Planning Application Ref: WA/18/17/T

Location : Rowan House, 7 Holly Tree Grove, Walberton

Description of works: 2m to 3m height and overall crown reduction to 1 No English Oak on north, east and west sides plus remove crossing and rubbing branches.

Block Plan

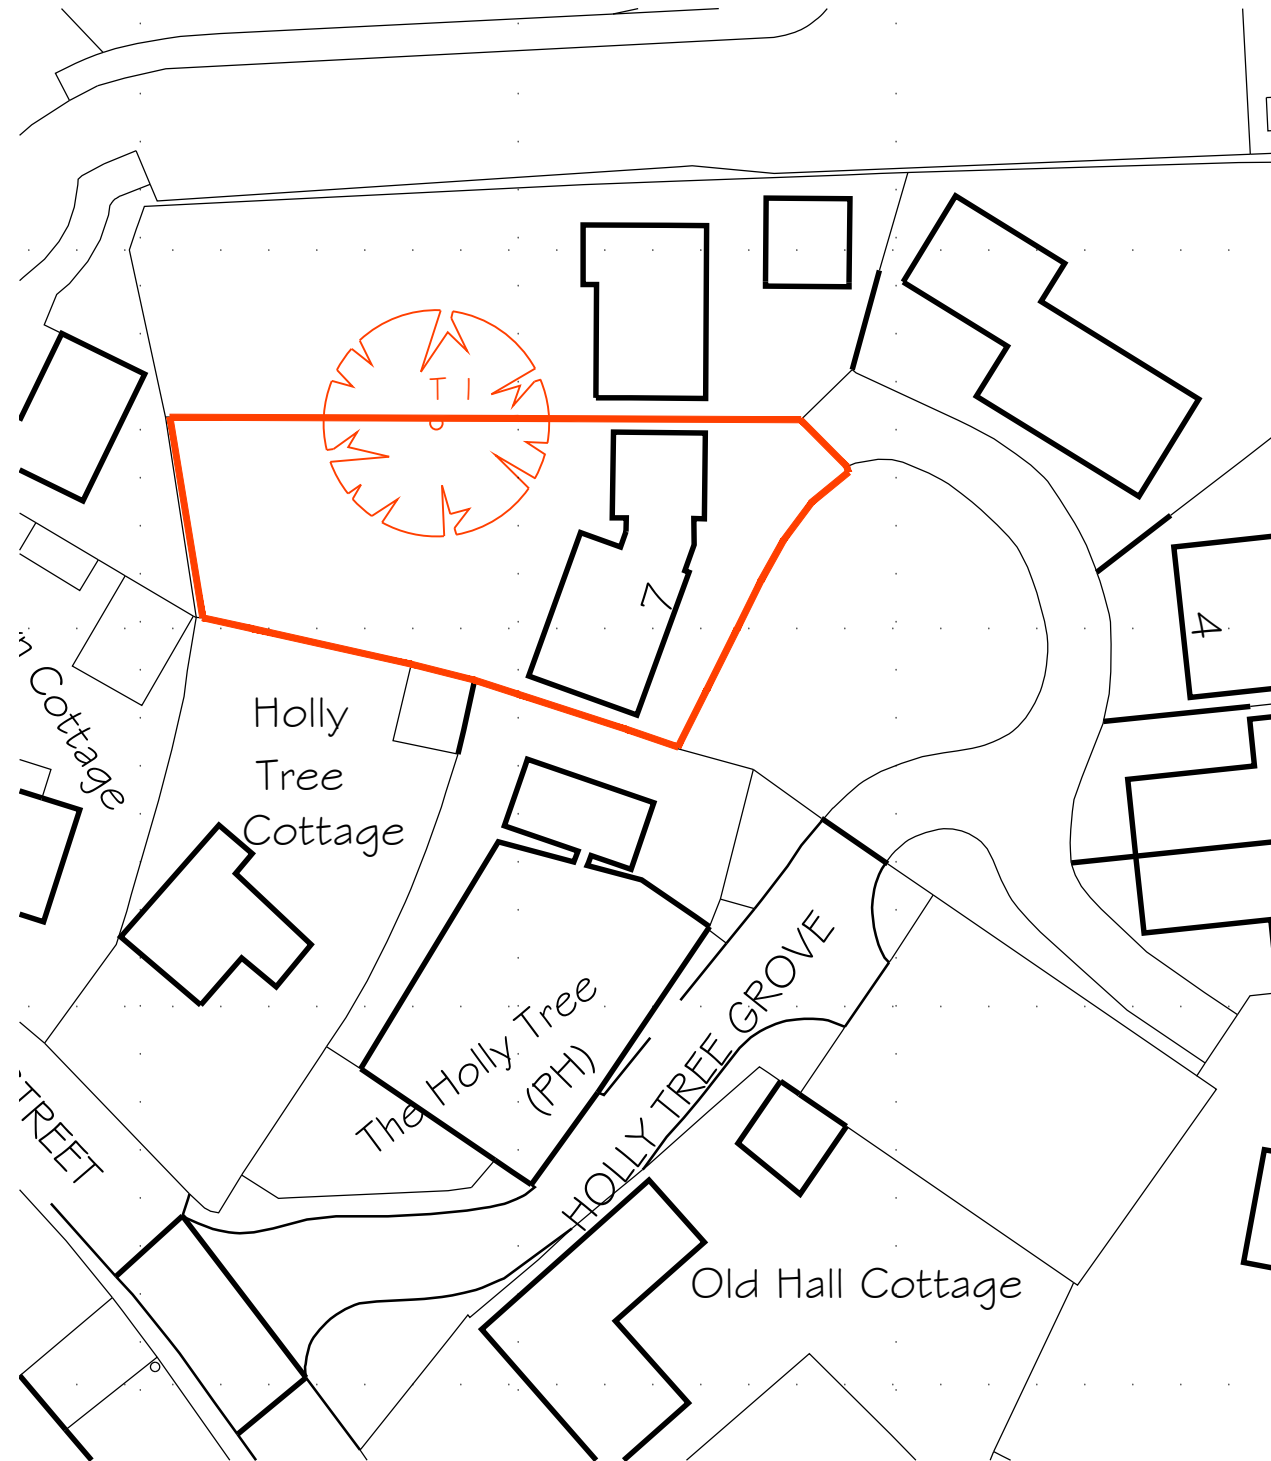
- This is a medium sized tree located in the rear garden and close to the boundary with an adjacent school so I can understand the owners concerns over safety and exercising some control over its future growth habit.
- CM Treecare have advised on the works specification and submitted the application on behalf of the trees owners.
- This is a good healthy specimen Oak tree of high amenity value and significance in the landscape.

- The amount of height reduction is acceptable provided that no stubs are left.
- The amount of lateral spread reduction that has been requested exceeds the recommendations of BS3998 and would in my opinion be detrimental to the ongoing health and vitality of the tree and undermine its visual amenity value in the landscape.
- The removal of crossing and rubbing branches is a very contentious matter because whilst rubbing branches might eventually lead to a failure at the contact point the risk of this ever happening has to be weighed against the fact that removal of one of each pair of branches might leave a large hole in the canopy and change the whole dynamic of the tree as it reacts to wind pressures thus causing more harm than good.

- I raise **NO OBJECTION** to the reduction in crown height by 2m to 3m overall for the reasons stated above subject to the standard pruning Conditions being applied.
- I raise **OBJECTION** to the shortening of the lateral branches by 2m to 3m and recommend that the applicant amends or re-submits seeking **1m to 1.5m reduction in their length.**
- Some removal of crossing and rubbing branches may be permitted but this can only be done under the direct supervision of the Arun DC Tree Officer [subject to agreeing on an appropriate day/date/time for this to take place]

- Where whole branches are to be removed and final cuts made close to the trunk or branch union they are to be made as shown in Figure 2 of BS3998:2010 and **MUST NOT exceed 100mm diameter.**
- Where branches are to be shortened back the final cuts are to be made at the correct angle shown in BS3998:2010 and adjacent to a live bud or lateral and **MUST NOT exceed 75mm diameter.**
- Removal of crossing and rubbing branches may be permitted but such work may only be carried out under the direct supervision of the Arun DC Tree Officer and his decision on which branches may or may not be removed is final. All open wounds are to be painted with 'Lac Balsam' wound sealant.
